Freedom Forever
Planset Revision Letter

8/13/2024
REV #1

BRADLEY HOCEVAR
257 BEACON HL RD , LILLINGTON, NC 27546

SITE PLAN			
JOB NO:	DATE:	DESIGNED BY:	SHEET:
442757	5/28/2024	N.W.	PV-2

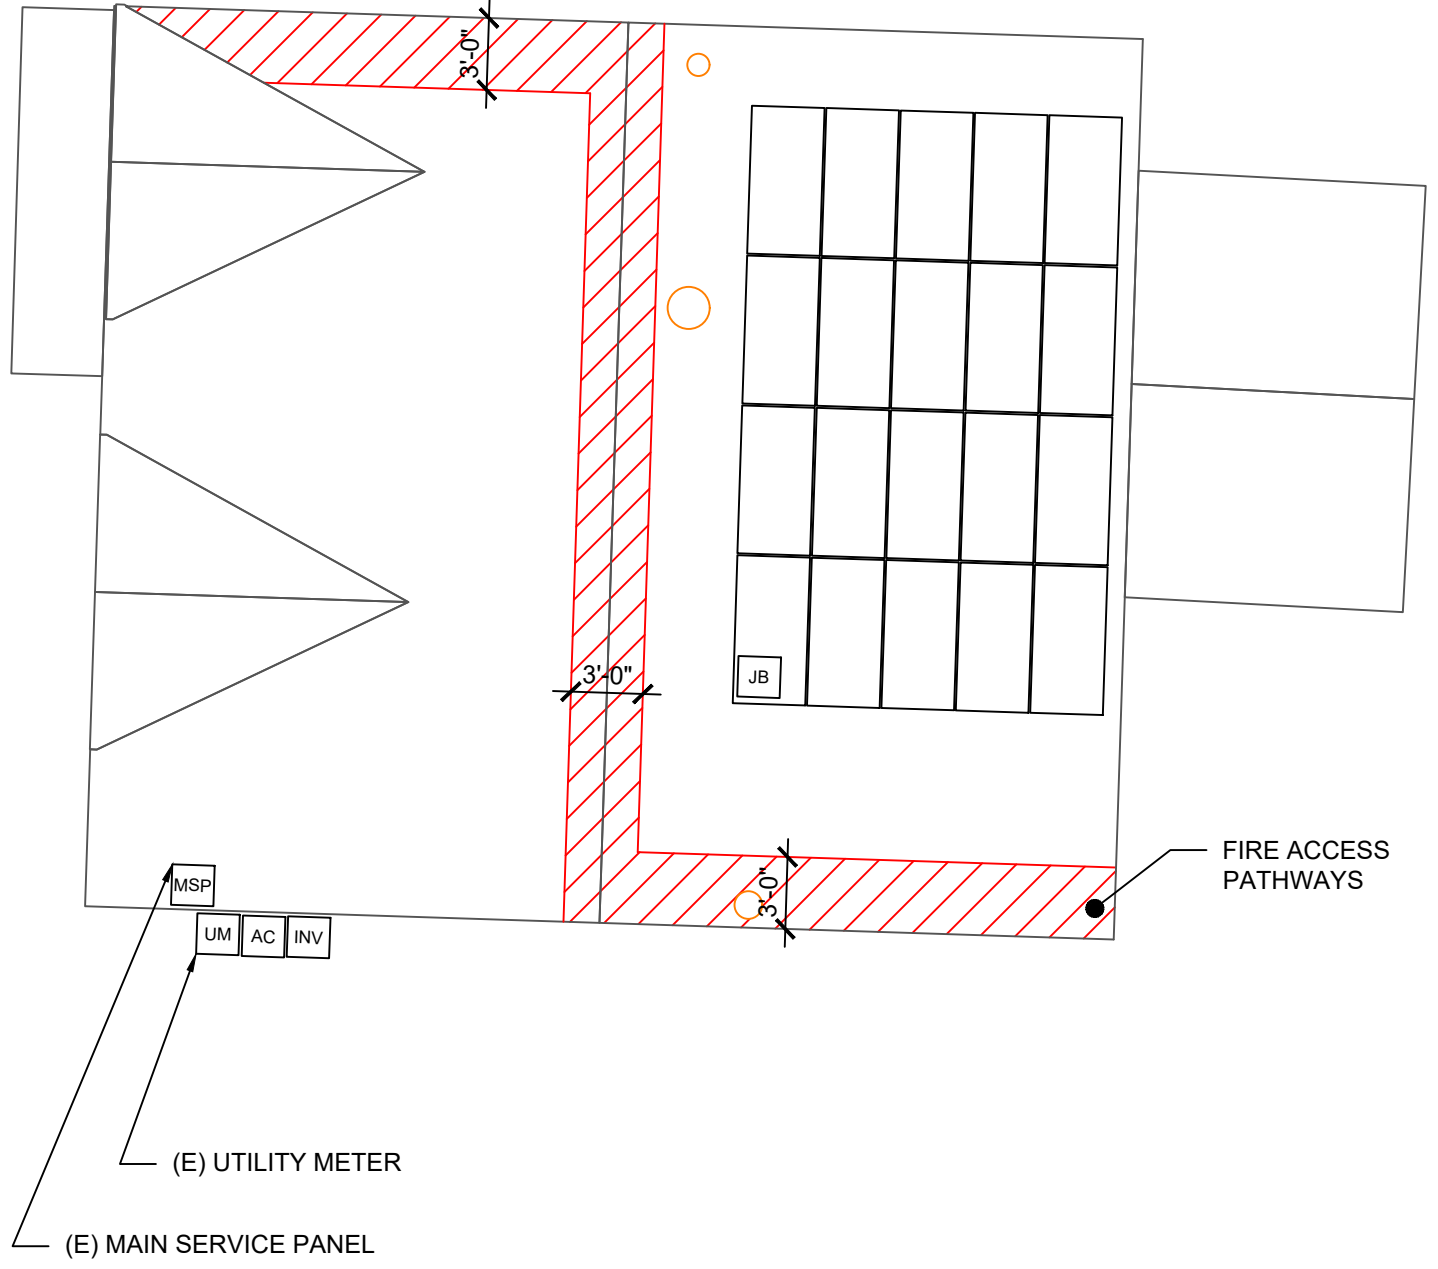
1. Layout revised to match install
